From: Dann, Fraser <fraser.dann@wsp.com>
Sent: 11 August 2020 14:33
To: Kate Mansell
Cc: Brooks, John
Subject: Interchange 26 - Yorkshire Water comments - 2020/91468 and 2020/91488

Orig Title: DRAINAGE MASTERPLAN
PHASE 2

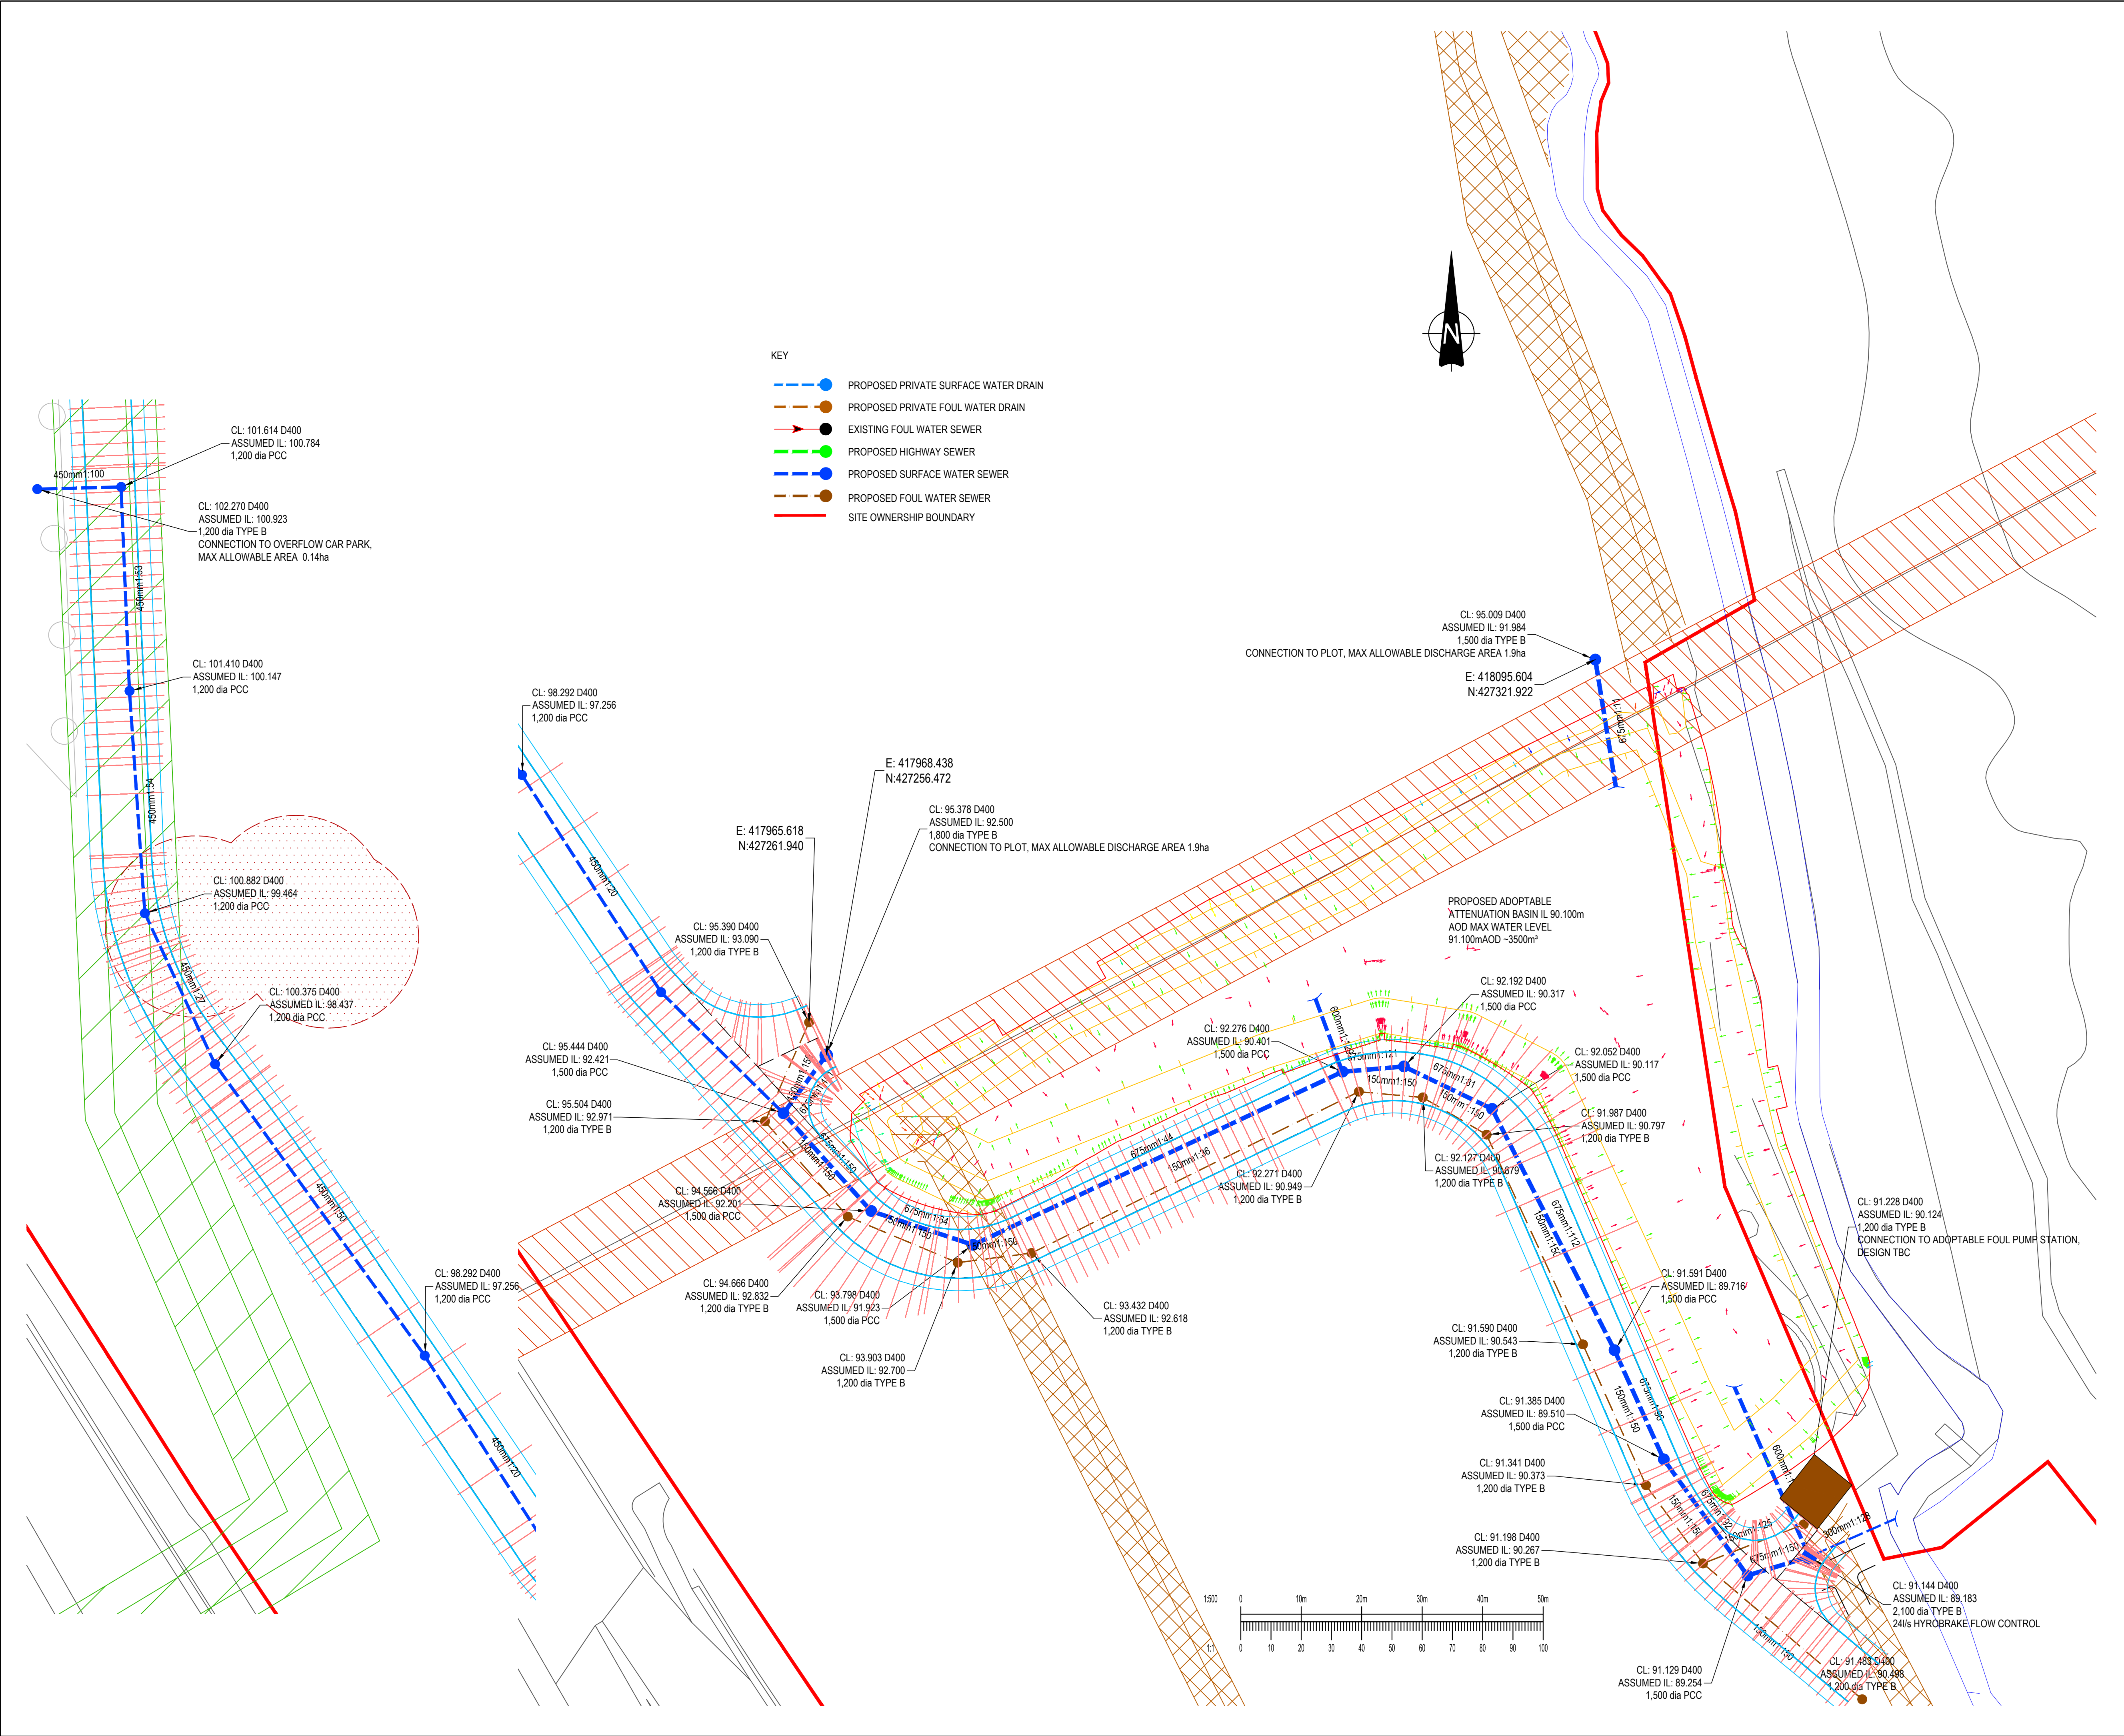
However, in respect of the other conditions, and the RM submission, the comments state *"From the submitted drawings, the public sewerage infrastructure crossing the site has not been accounted for, in particular, access to the Combined Sewer Overflow (CSO) to the north west of the site. The clean water infrastructure may also be affected by the development proposals; further information is required."* The YW Sewer Overflow is within the area of land to be retained by YW and hence will not be negatively impacted by the proposed development (see screenshot below). The access to the overflow will therefore be as existing through the YW compound. Curtins have reviewed the other areas of the site which could potentially be impacted by the proposed development and did not identify any other issues either.

In respect of waste water, YW have also requested a detailed masterplan which includes the surveyed positions of the sewer apparatus (including the CSO) crossing the site and which indicates the required access routes to the CSO, with all the relevant sewer stand-off distances adhered to. They have also requested *“the relevant phasing information regarding the construction and discharge of foul water to the public sewer network.”* The Foul water connections for the Phase 2 plot are shown on the information submitted for the Phase 1 RM application – we have not shown these for the future Phases 3 and 4 where buildings are proposed, as these are not yet fixed. This information will be provided with the submission of the relevant conditions and RM applications for those phases. We are putting in infrastructure as part of Phase 1 but this is all shown on the submitted information. Please could you advise if anything further is required?
